DECISION DELEGATED TO DEVELOPMENT MANAGER

Application No: H18-0826-20 **Applicant:** Mr & Mrs K Wiles
Proposal: Extension & Alterations
Location: 258 Bridge Road Sutton Bridge Spalding
Terminal Date: 1st December 2020

SITE PLANS
FLOOR PLAN & ELEVATIONS.
- PROPOSED.

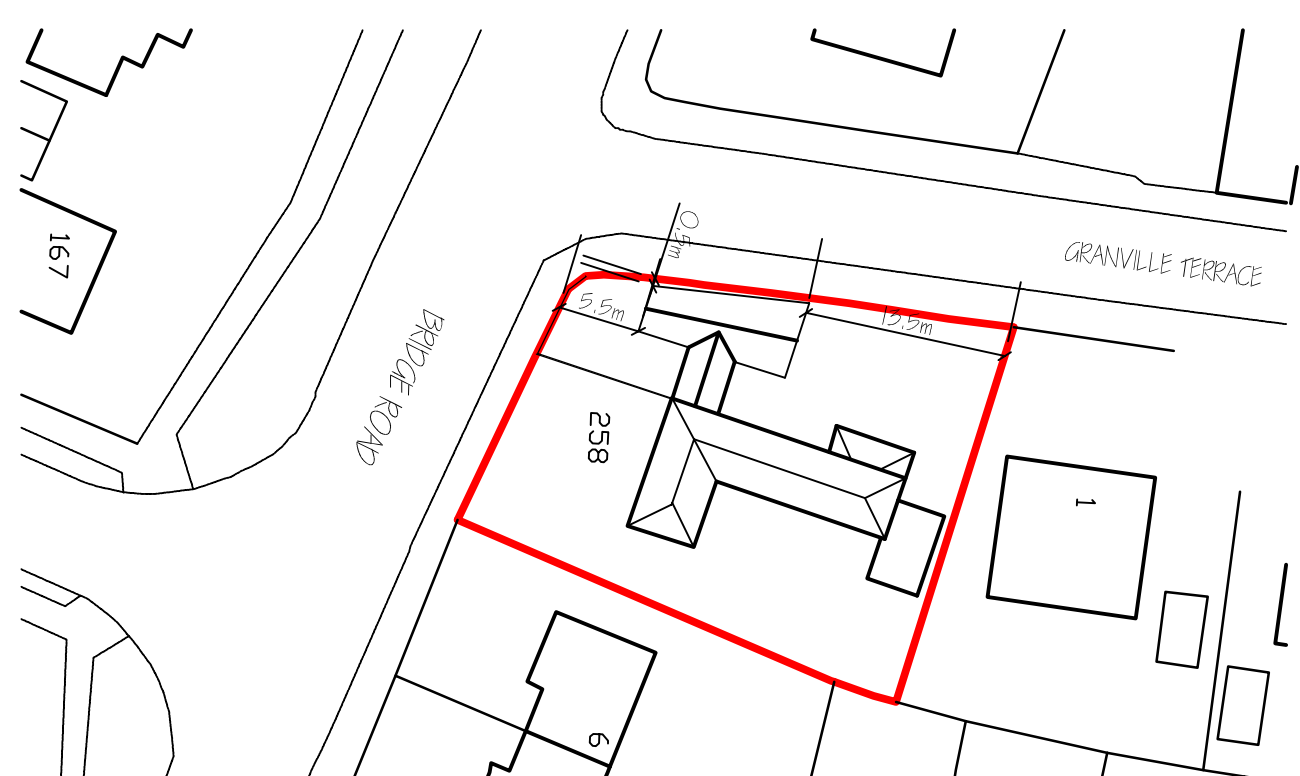
The development proposals entail significant alterations to the current timber outbuilding. The shed roof will be replaced for a gable pitched roof. Both gables ends will face north and south, respectively. The apex height of the building will increase approximately from 3.40 metres to 4.25 metres by the proposed works.

Despite such improvements against the refused development, it is considered that the proposals persist in failing on the materials considerations contained in the reasons for refusals.

The footprint of the structure will remain large. The height will be even increased by nearly 1 metre further and sharp angle of the gable pitched will exacerbate the prominence of the building onto the street scene. No harm will be perceived from the adjoining Granville Terrace because of the high mature hedge that obscure views onto the structure.

With regards to the external materials, timber cladding will remain across all elevations which is at odds with the character of the local area. Facing brickwork predominates the visual appearance of other properties in the vicinity. The wide use of timber for the external walls of such sized outbuilding at such prominent location onto the street scene will appear uncharacteristic in relation with other properties in the surroundings.

In summary, the house extension might contribute to improve the design of the current outbuilding but the proposals for roof replacement, external wall treatment and the keeping of the outbuilding at such prominent location will make the development still unsympathetic with the character of the area.
